SSD 11606719– Request for advice on the response to submissions for a State Significant Development Application for Eastern Creek Recycling Ecology Park Throughput Increase

Blacktown City Council's submissions to SSD 11606719 - Eastern Creek Recycling Ecology Park Throughput Increase

TITLE
SITE WORKSHOP

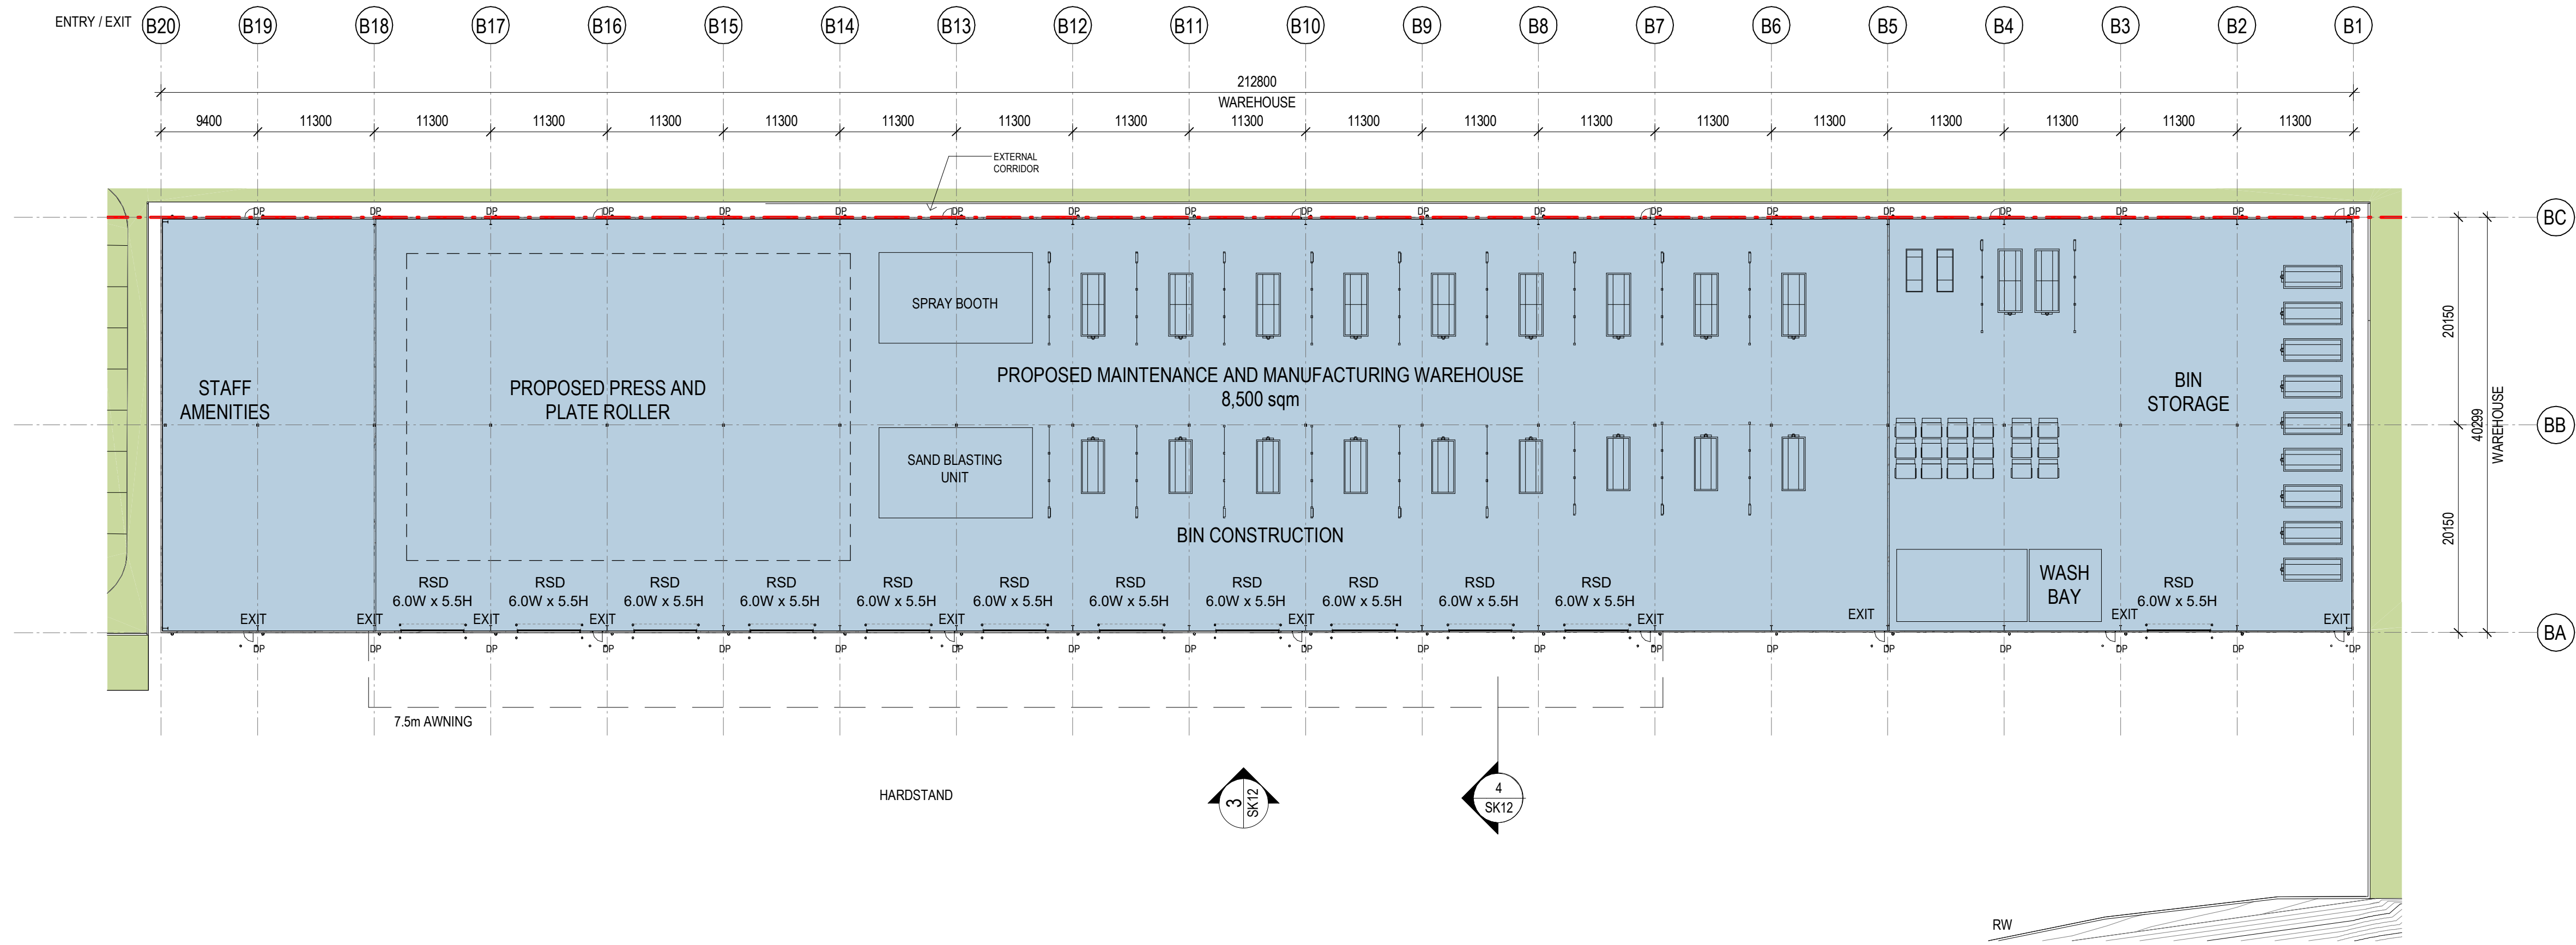
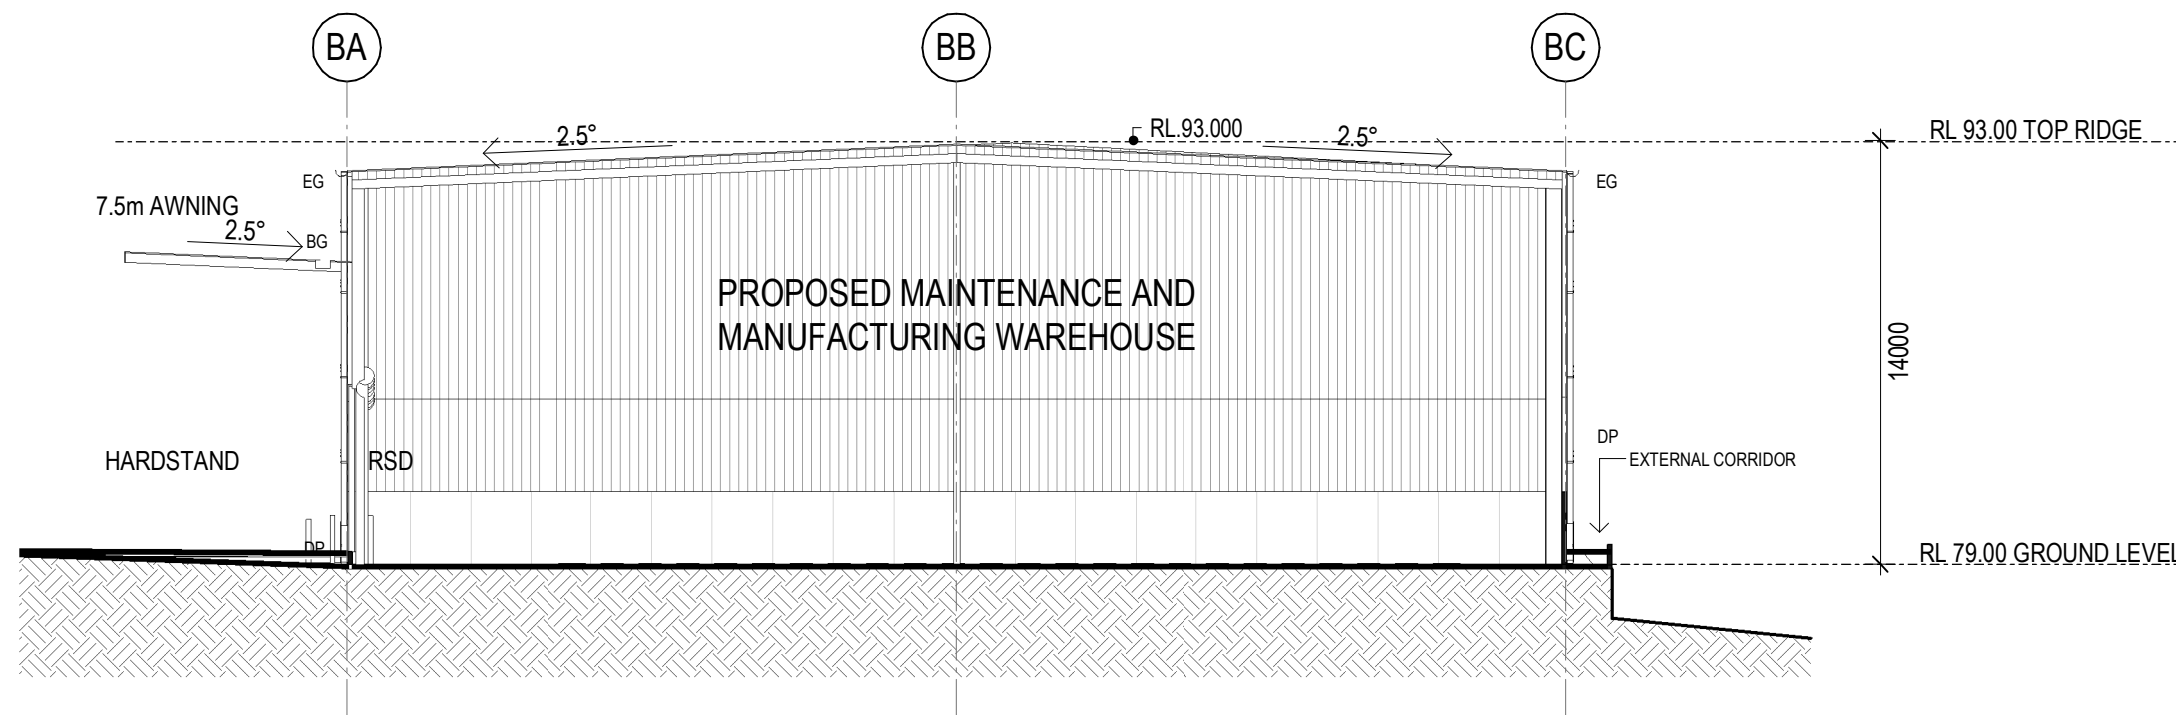
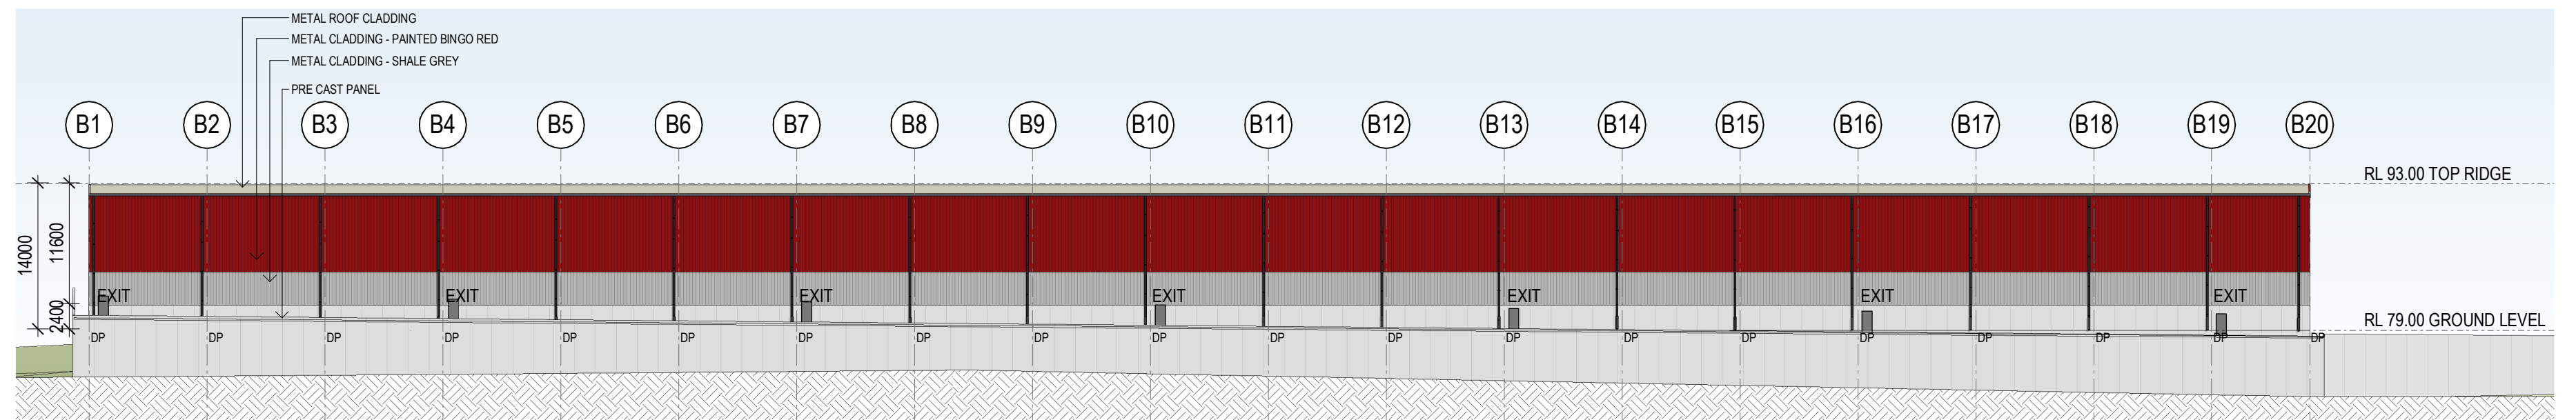
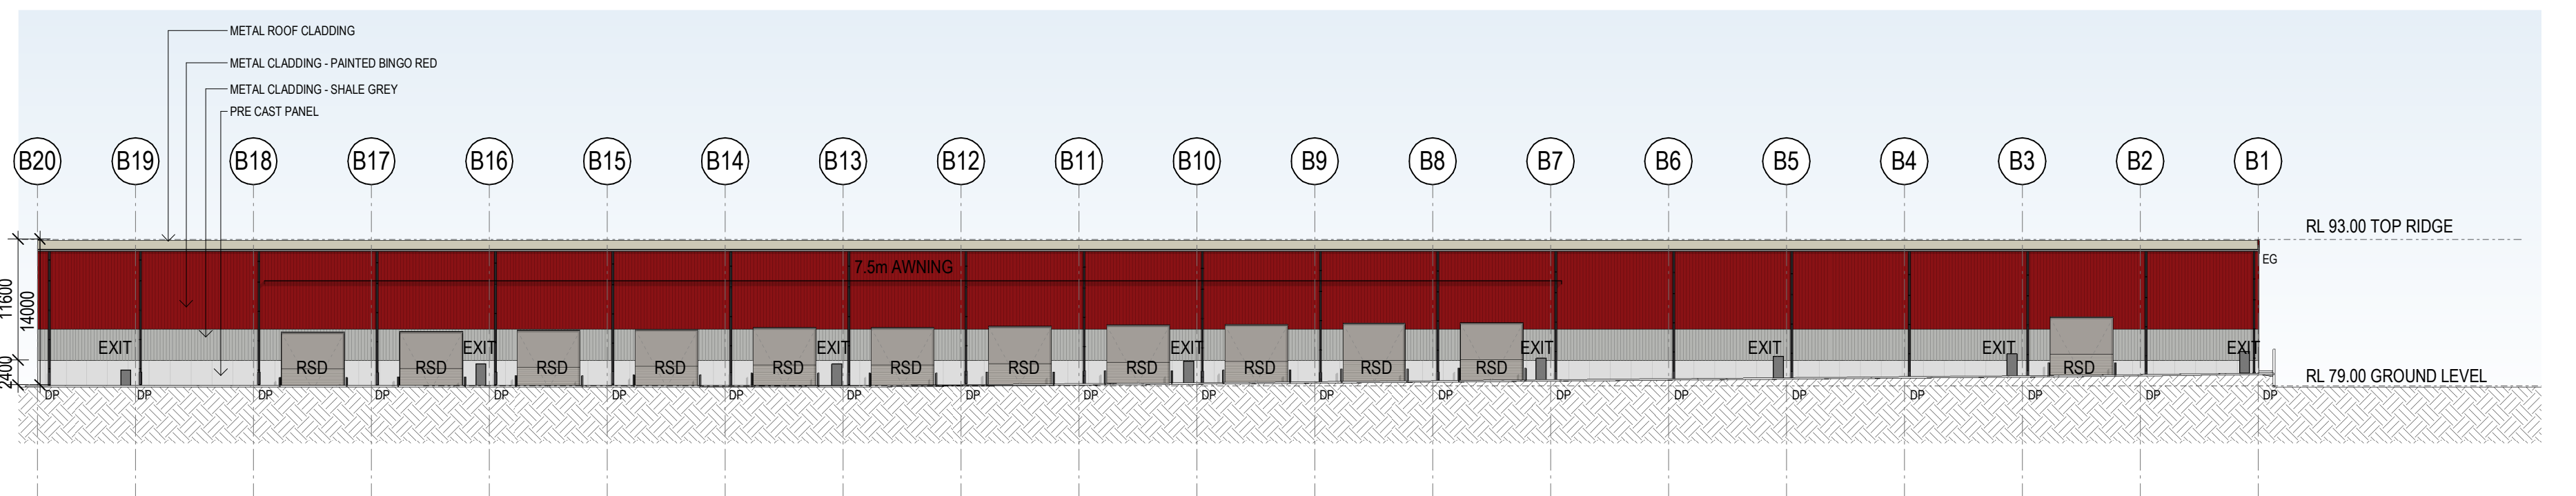
The architectural plans have not been updated to show the setbacks from the boundaries. This issue remains unsolved.
